Our Ref: AL/66/14/PD
Your Ref:

Application for Prior Notification for a commercial development

Development Prior Notification Under Class MB for change of use from agricultural building to 2 No. dwellinghouses (Use Class C3)
Location Sack Lane Dairy Sack Lane Lidsey

PROJECT				Proposed conversion of existing barn at Sack Lane Dairy, Lidsey.	
SUBJECT				Proposed Plans and elevations	
SCALE		DATE		DRAWING No	
1:100		Mar 2013		2012 / 01 / 10	
DRAWN		CHECKED		Rev A

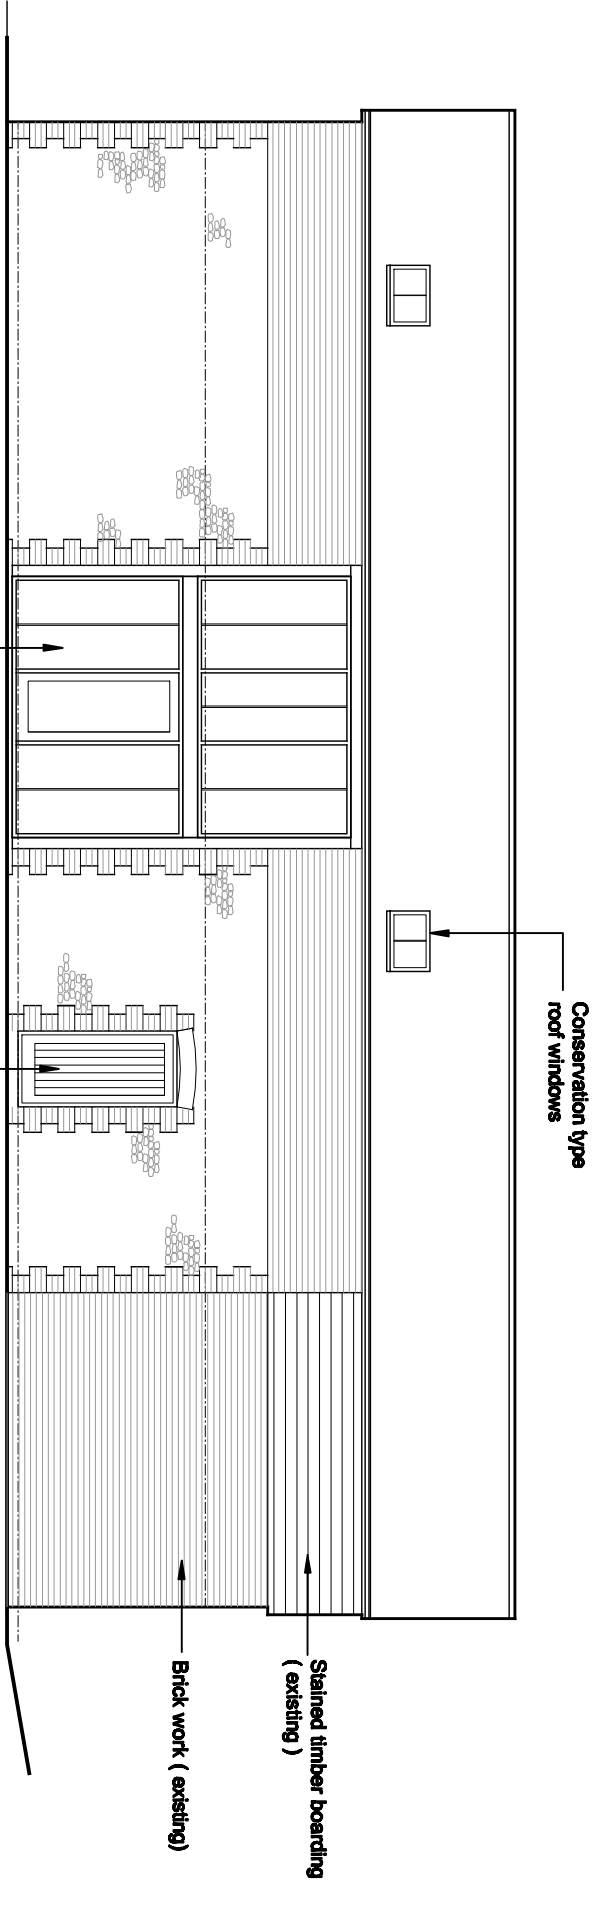
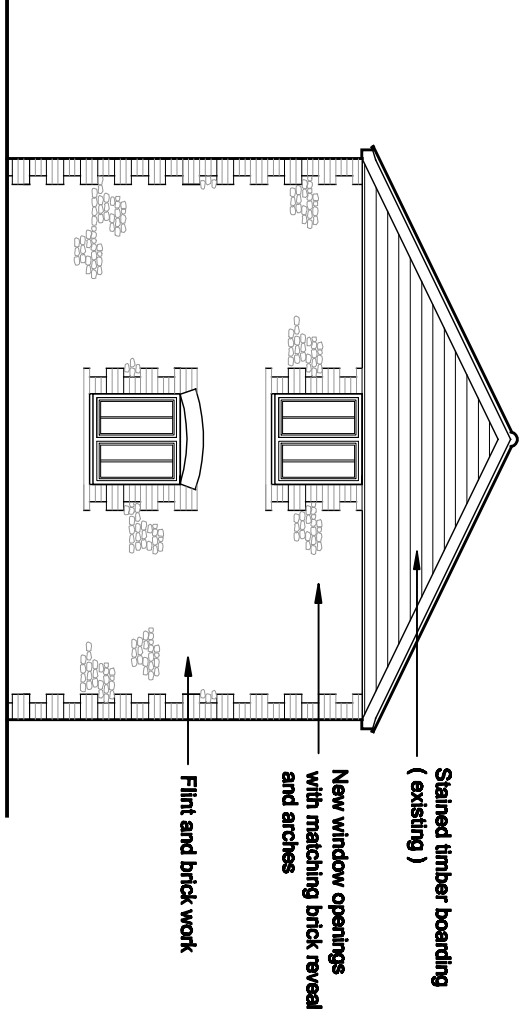
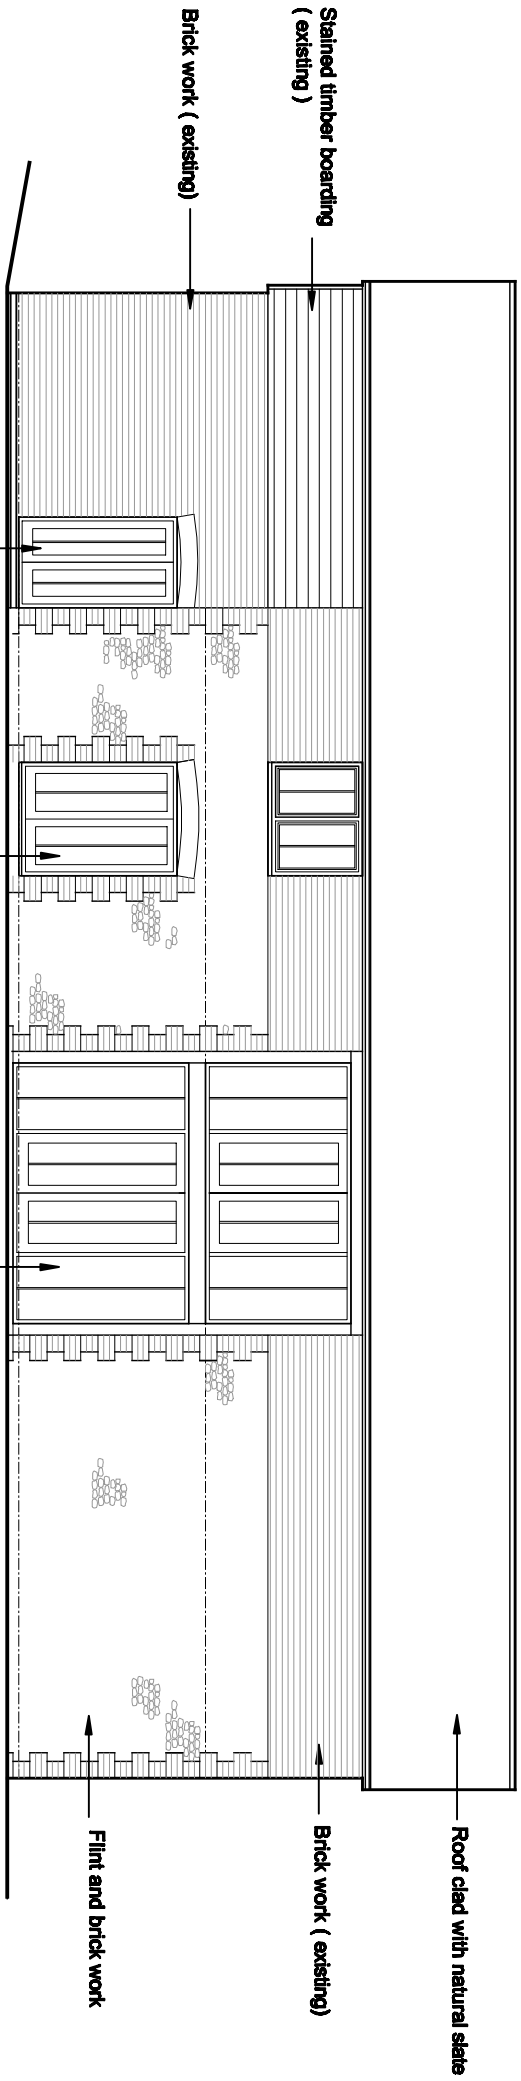
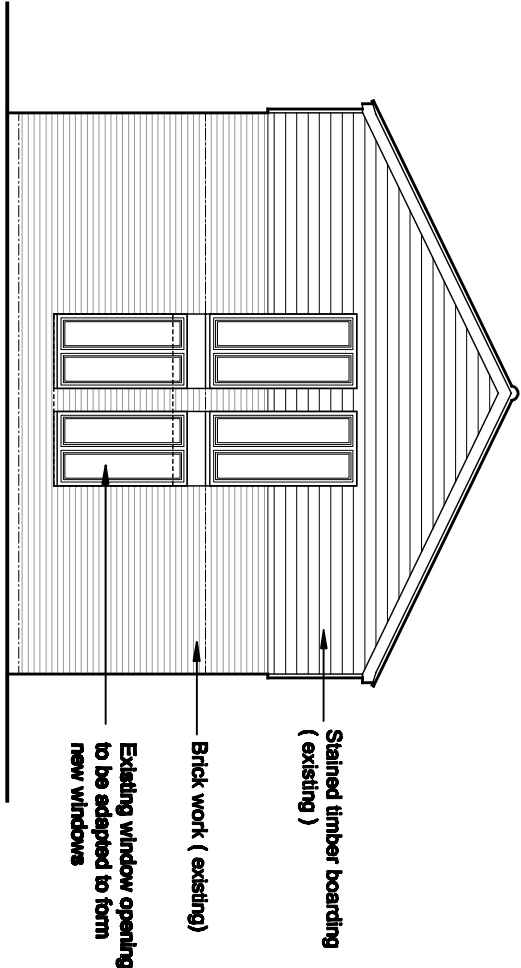
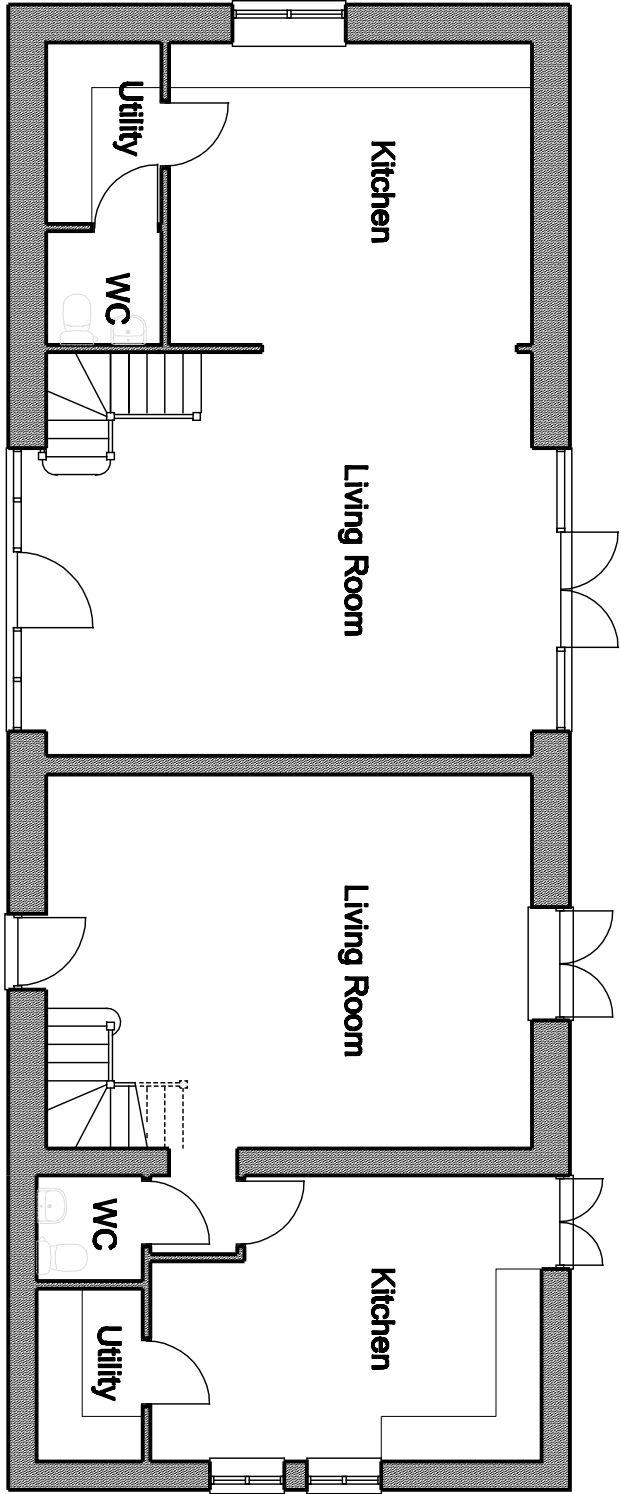
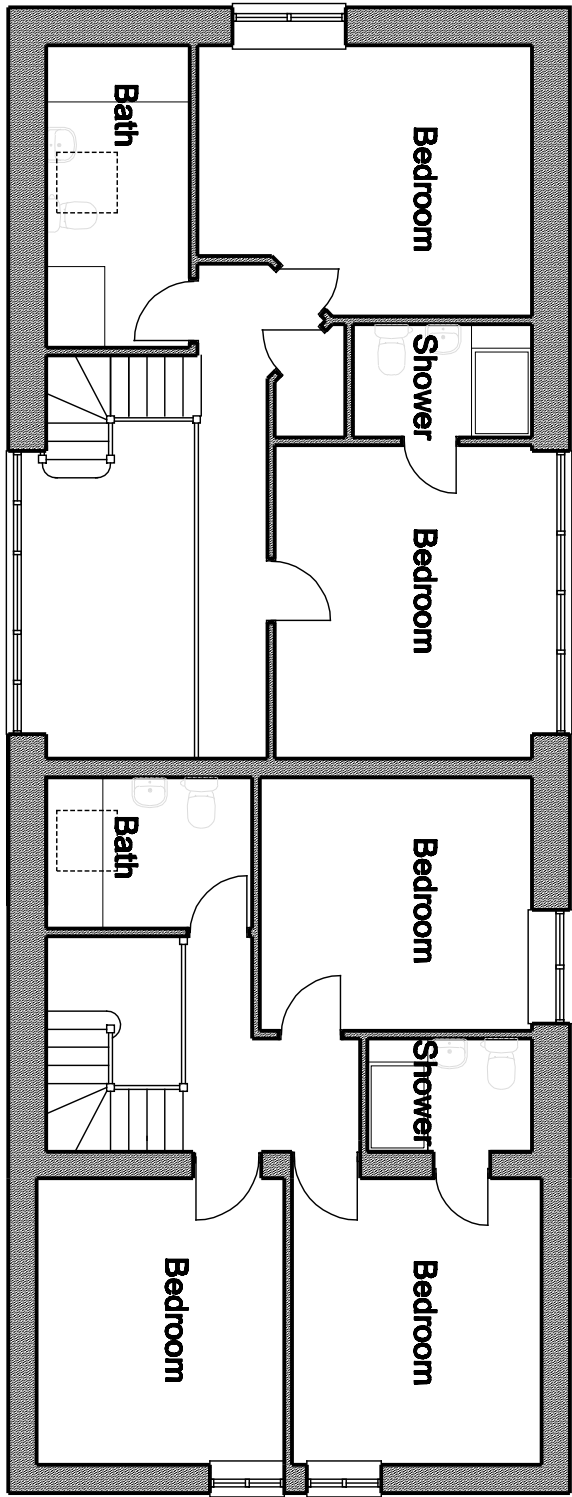
1. The position of the conservation light to the bathroom of the 2 bedroom unit shown on the roof plan does not coincide with the location shown on the floor plan.
2. Curtilage - The area of land immediately beside or around the building should not be larger than the land area occupied by the agricultural building. (See GPDO 1995 (as amended) Interpretation of Part 3)
Therefore, please submit amended plans accordingly.
